Our Ref: FG/82/09/

3rd August 2009

Changes to existing front balcony by replacing tiled perimeter with new glazed guarding
20 South Drive Ferring

20 SOUTH DRIVE, FERRING
Proposals 02

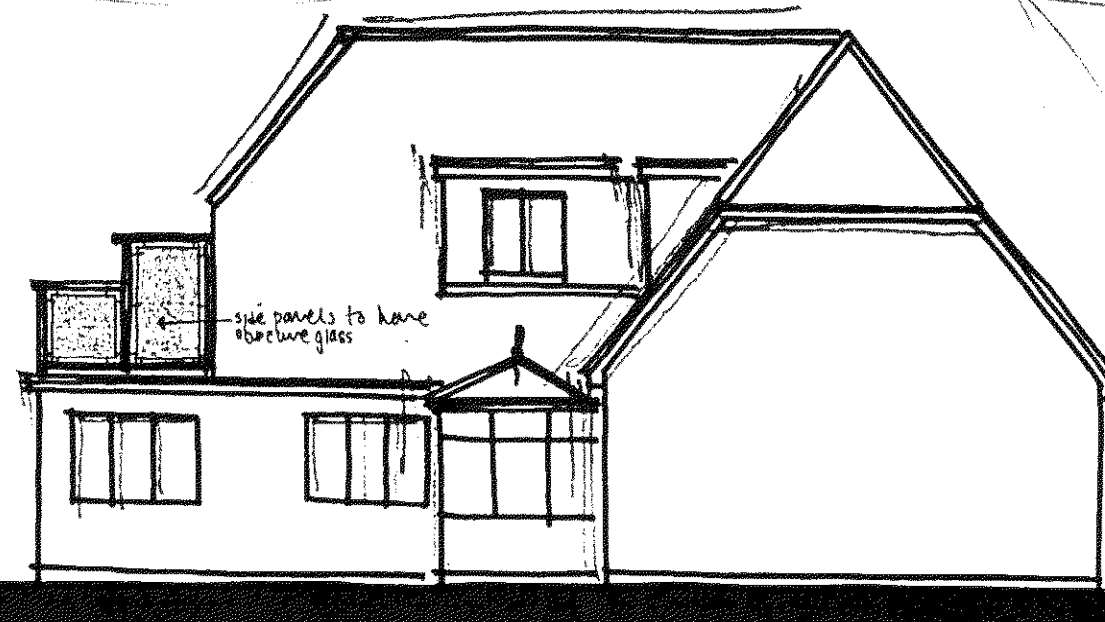
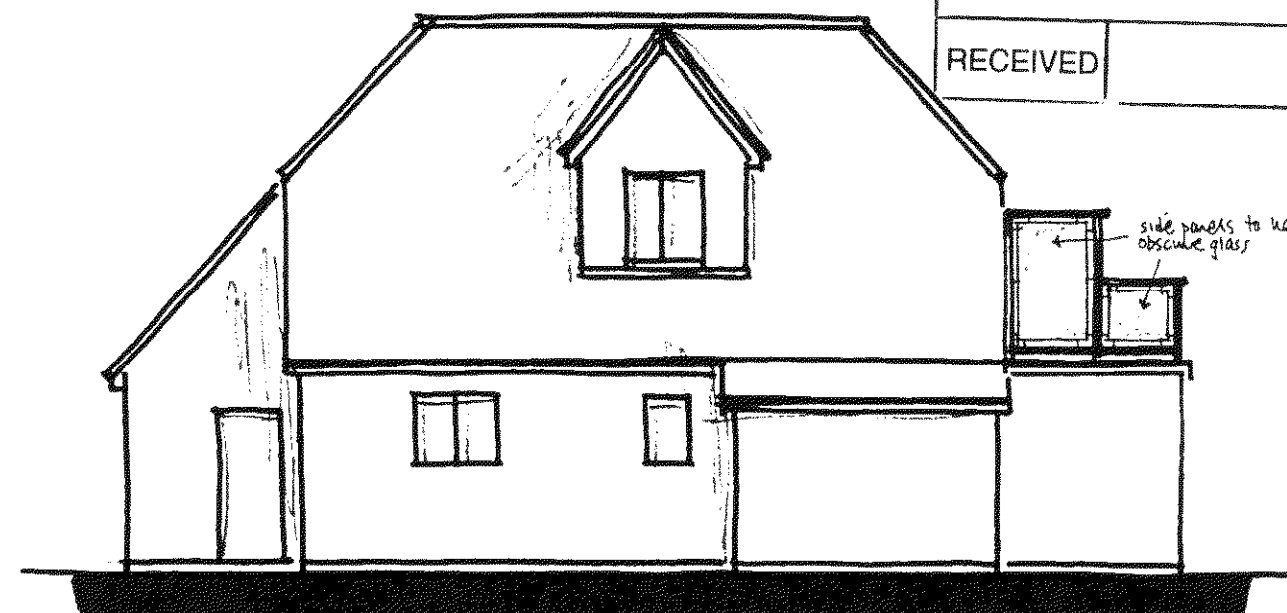
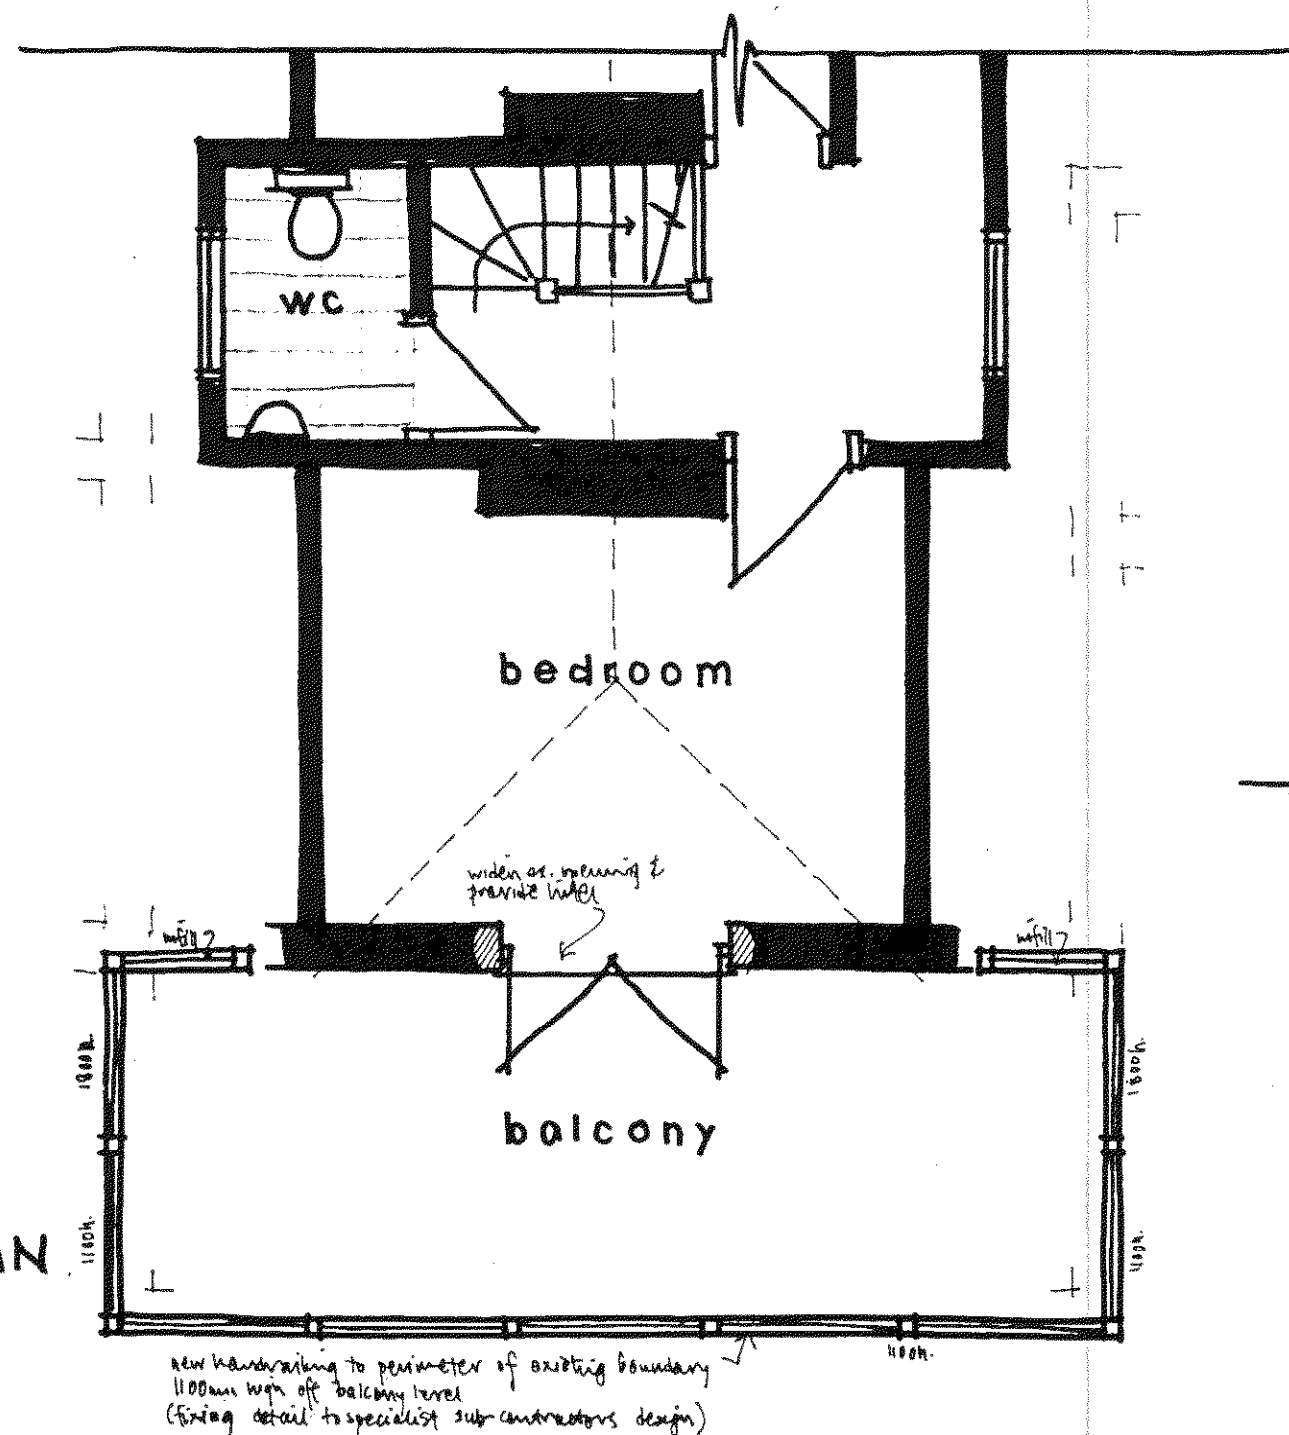
The proposals substantially alter the main elevation to the building. The removal of the existing tile hung fascia increases the size of the balcony to the extent that it would overlook the adjoining properties. The provision of glazed screens to the perimeter of the balcony do not accord with the character of the surrounding properties. The proposals conflict with the provisions of Policy GEN 7 of the Arun District Local Plan. ☐

The parish Council objects to the proposals on the above grounds. ☐
